**PETERSON BOULEVARD & SPACE VILLAGE AVENUE
COLORADO SPRINGS, CO**

TRAFFIC IMPACT STUDY

PROJECT NO. 017-1754

Add PCD File No. SP-17-009 & SF-18-016

Existing Traffic Volumes

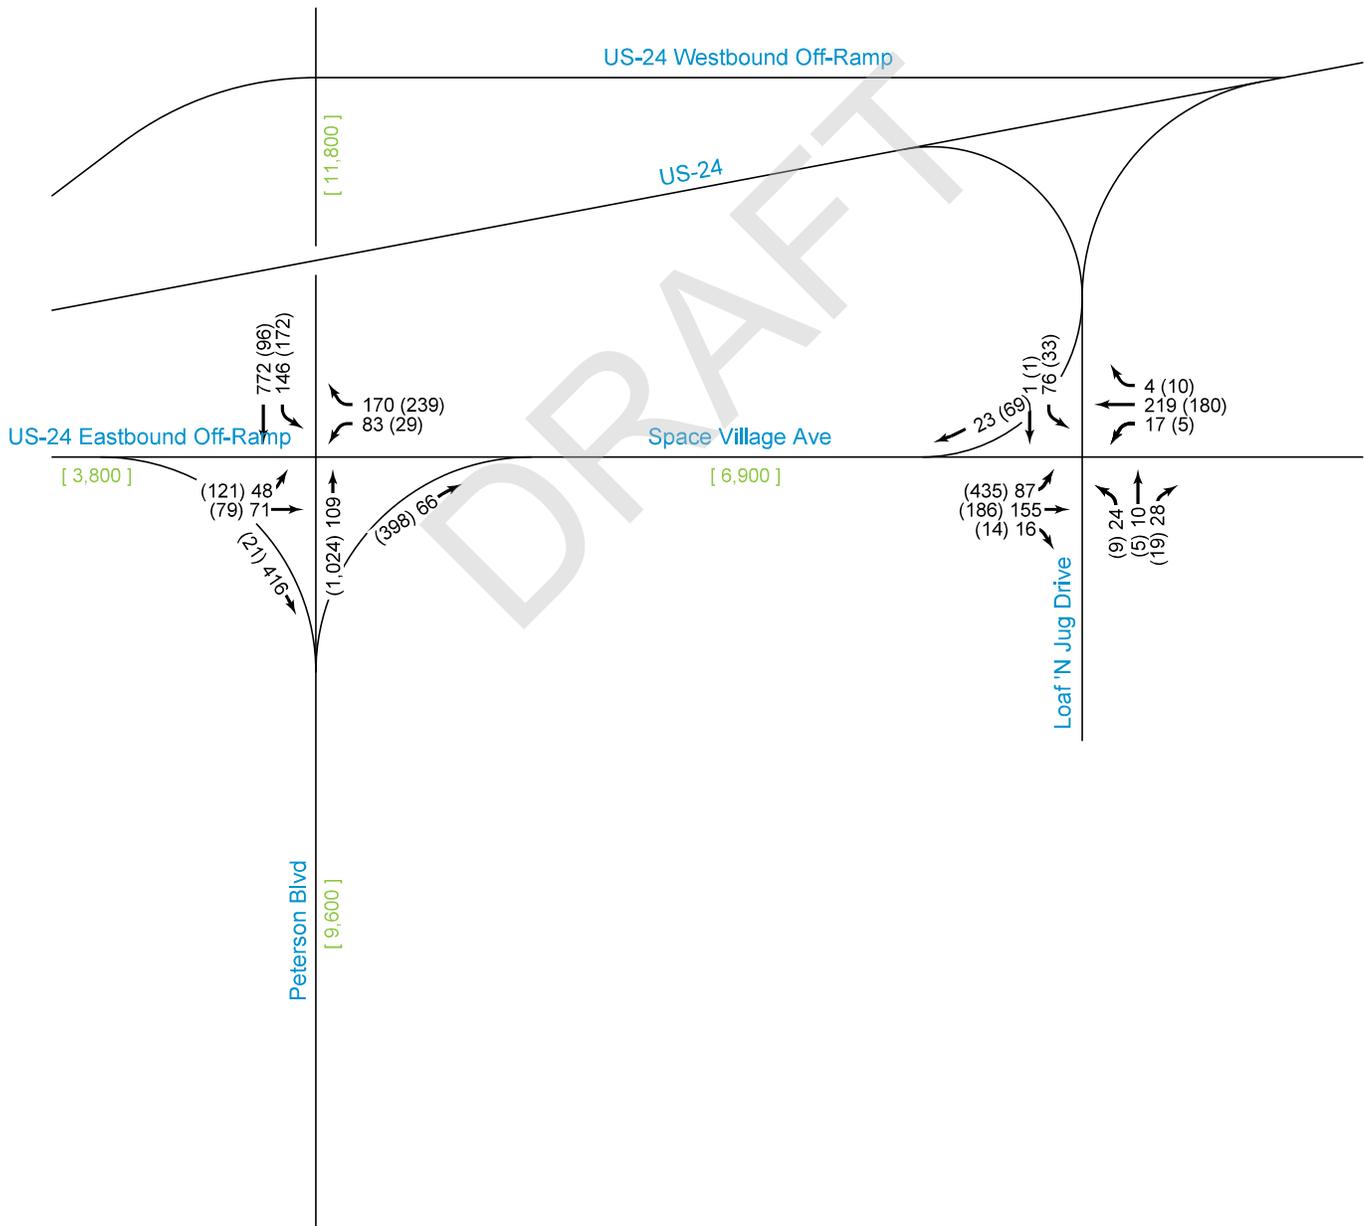
With this area involving multiple jurisdictions, for clarification identify (via narrative and/or exhibit) which jurisdiction owns/maintains which road.

Existing Lane Configurations and Traffic Control

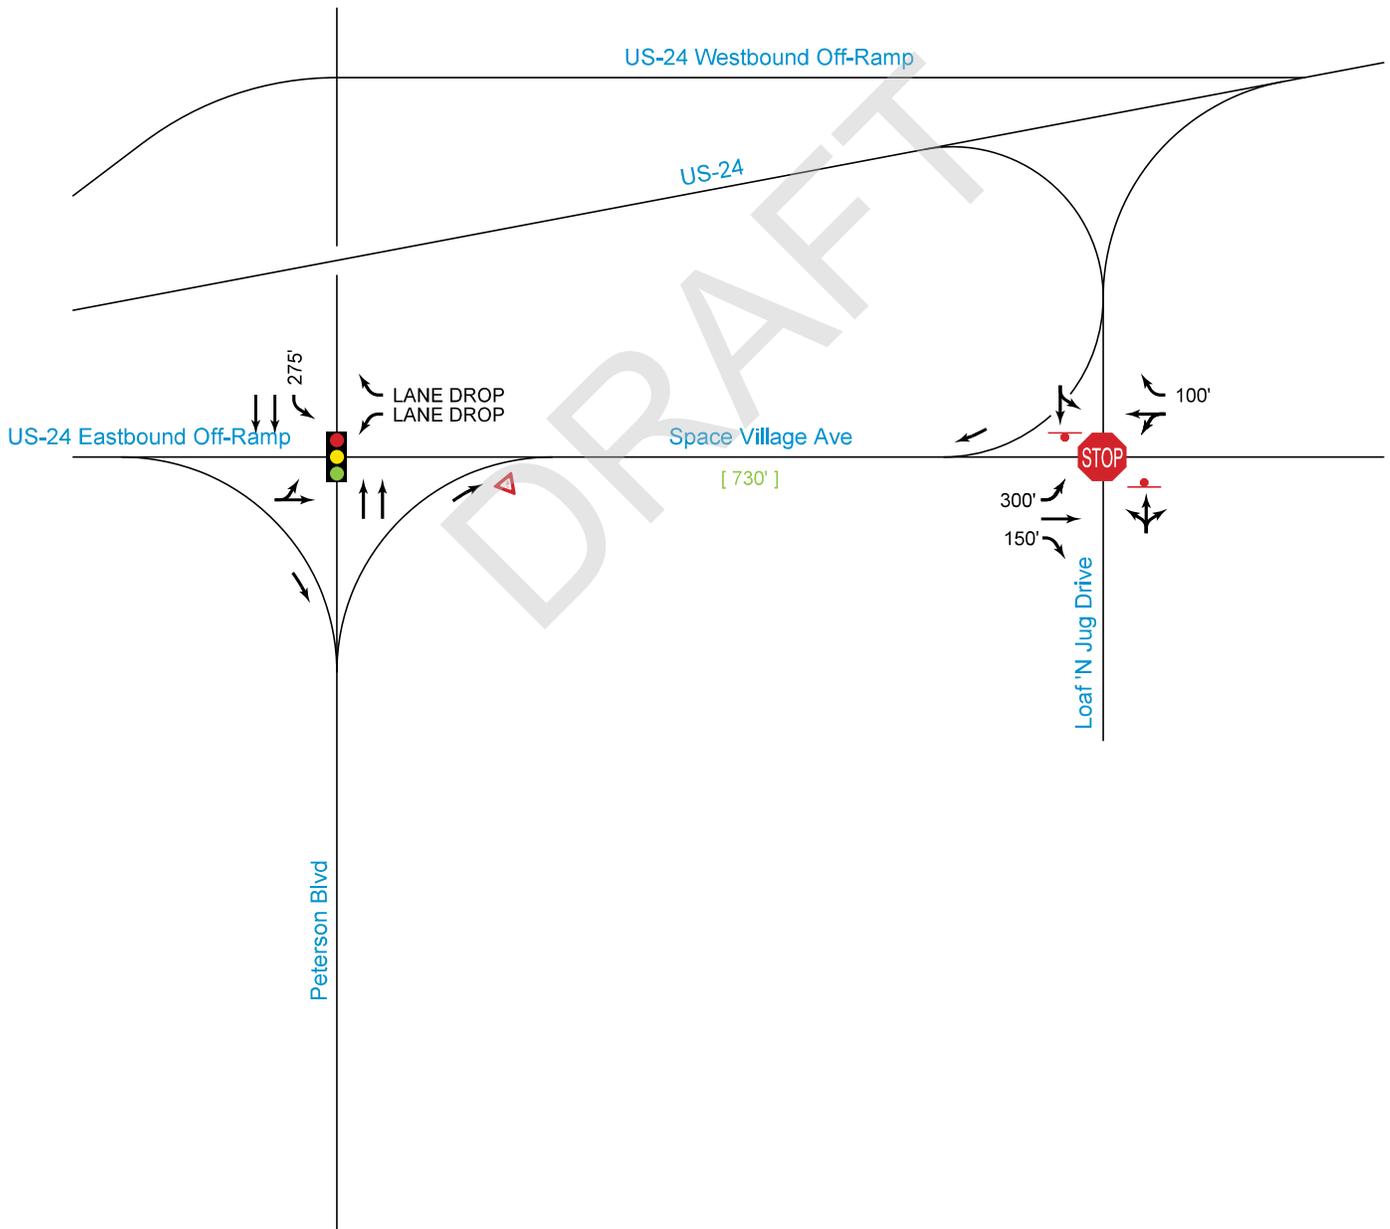
List ECM criteria for stacking, storage, and taper for every affected auxiliary lane and access and for each access state whether the criteria is met. If it can't be met, state the required modification so that it can be met.

Existing Conditions Capacity Analysis Summary

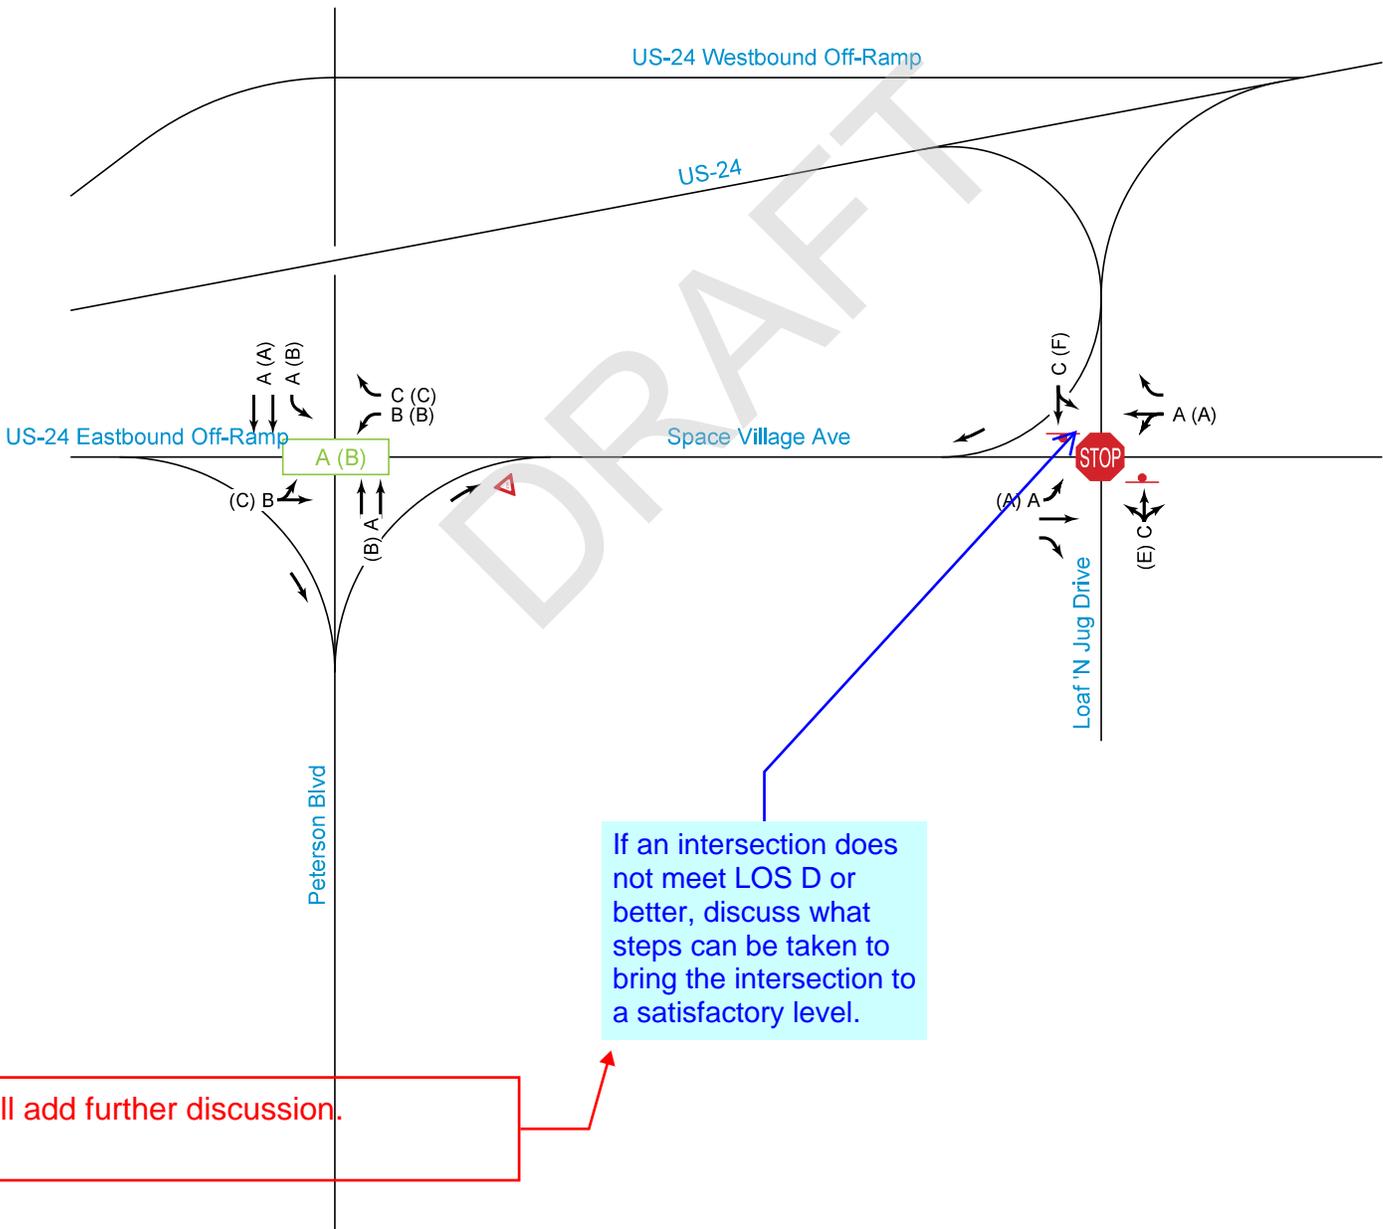
If an intersection does not meet LOS D or better, discuss what steps can be taken to bring the intersection to a satisfactory level.

With queueing backing onto US-24, why is the Synchro analysis at Space Village/Peterson be at LOS B or better?
